Environmental Statement Consolidated Errata and Changes

Hinkley Point C Connection Project

ES VOLUME 5.30B.1 – ENVIRONMENTAL STATEMENT CONSOLIDATED ERRATA AND CHANGES DOCUMENT

NG INVESTMENT No.	APPLICATION No.	GIS
20897	EN020001	A3
FIGURE No.	DRAWING No.	SCALE
3.3.16	G1979.1535.16Z	1:5,000

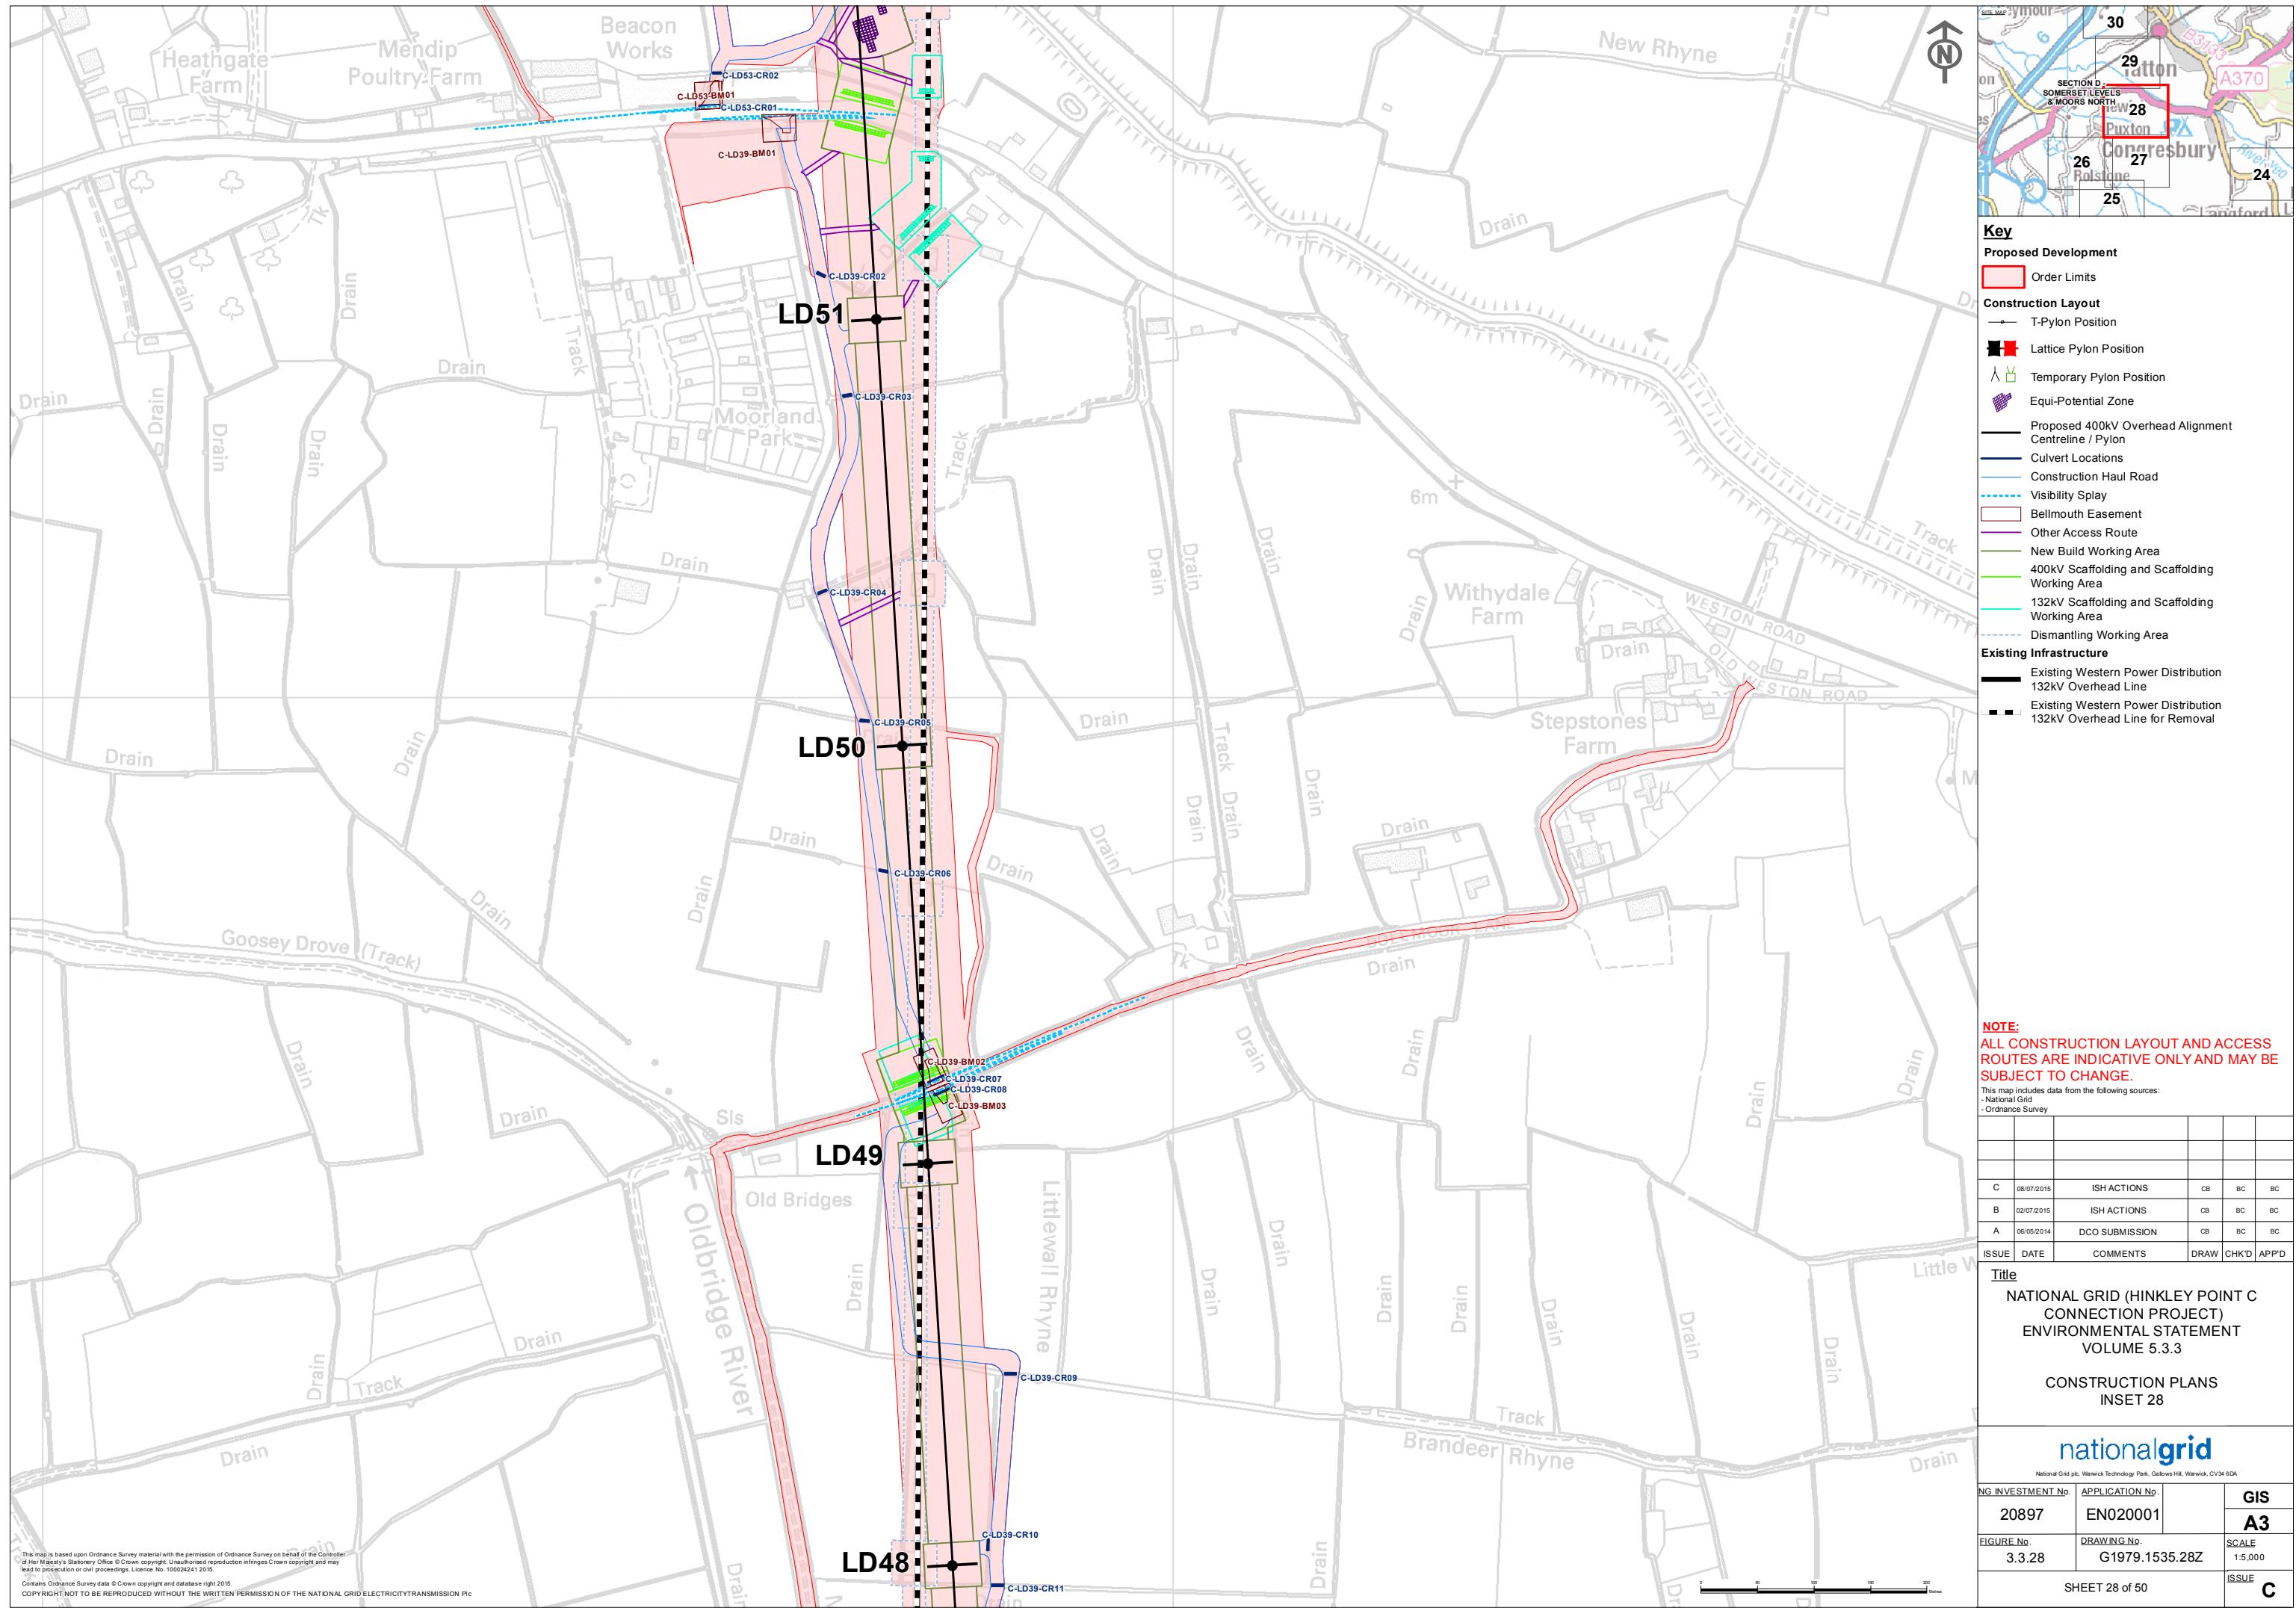
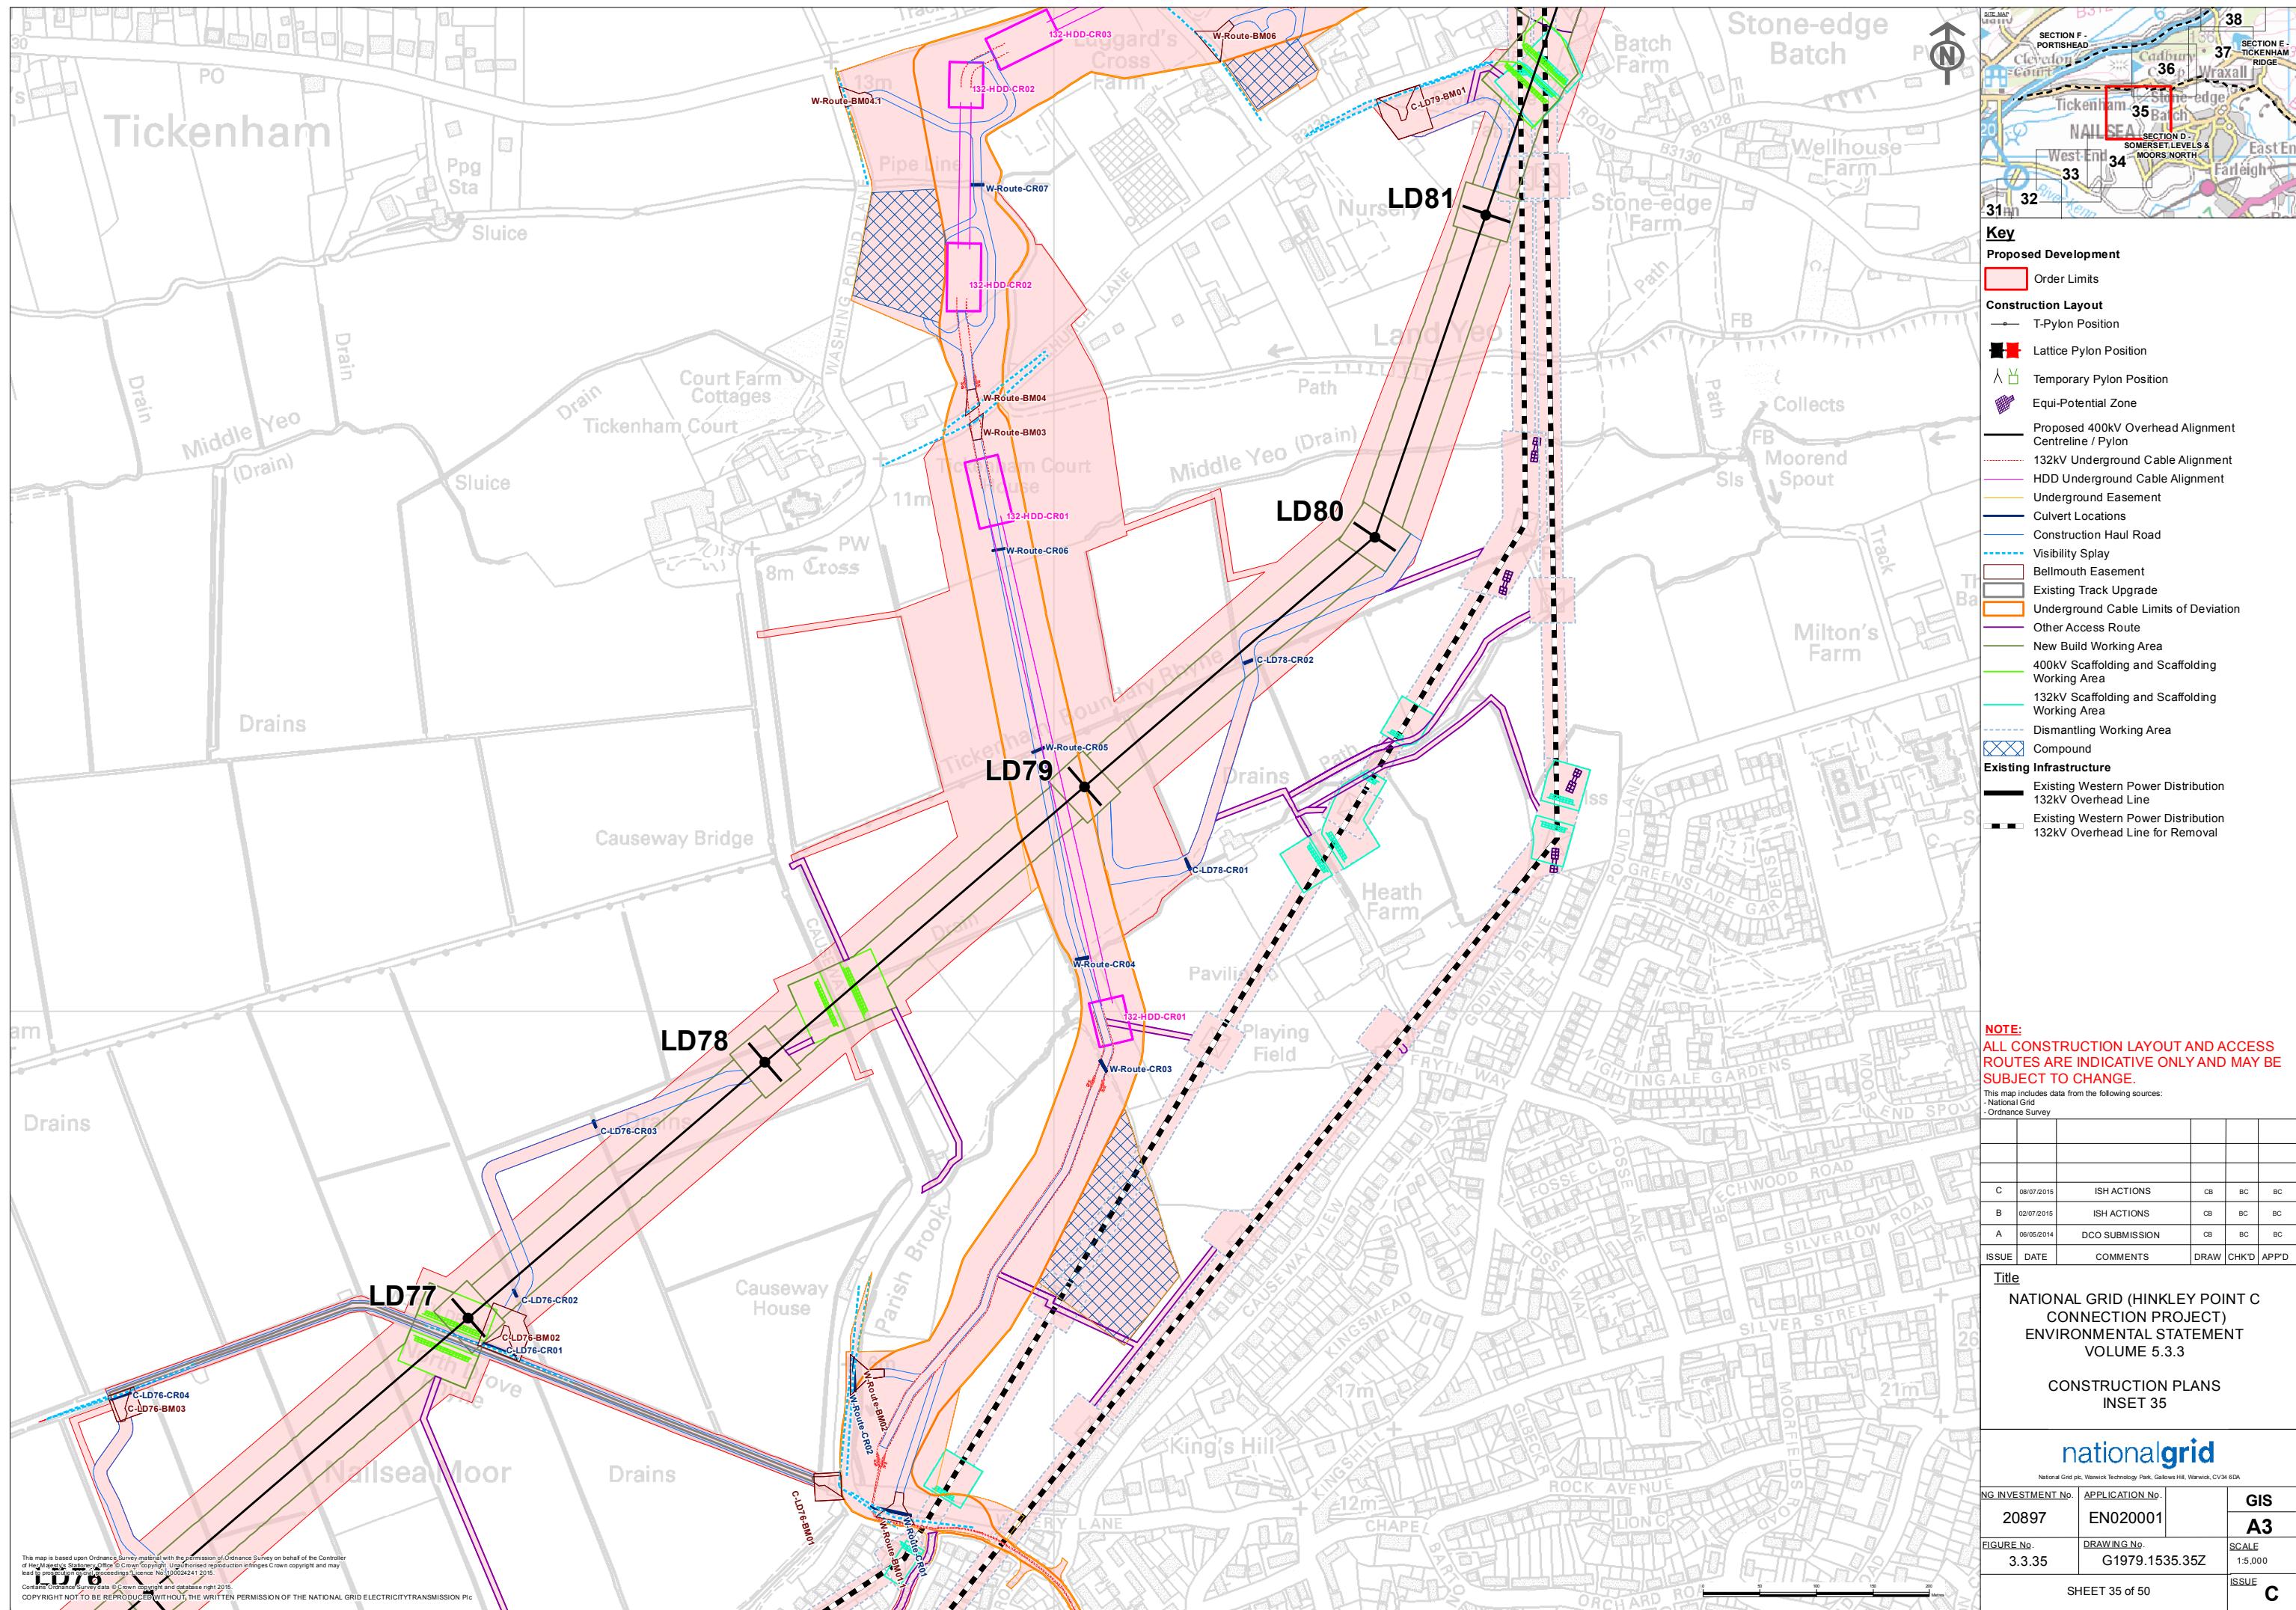
ES Volume 5.3.2, Appendix 3E ES Volume 5.3.3.2, Figures 3.3.16, 3.3.28, 3.3.35, 3.3.36, 3.3.49 and 3.3.50	<p>ES Volume 5.3.2, Appendix 3E (Bellmouth Schedule) should be read as amended due to a variety of changes discussed during the Issue Specific Hearings as follows:</p> <ul style="list-style-type: none"> • Fletchers Lane – two additional bellmouths (400-UG-BM01A and 400-UG-BM01B) added to provide safe access across adopted highway. • Moorland Park – existing bellmouth (C-LD39-BM01) relocated due to the realignment of the proposed construction access (see below) north of Moorland Park. • Clevedon Road – existing bellmouth (W-Route BM05) removed. • Whitewick Lane – existing bellmouths (ZZ7-BM01 and ZG7-BM01) removed. <p>ES Volume 5.3.3.2, Figures 3.3.16, 3.3.28, 3.3.35, 3.3.36, 3.3.49 and 3.3.50 (Construction Plans) should be read as amended by Annex B of this document.</p>	Issues raised at Issue Specific Hearings
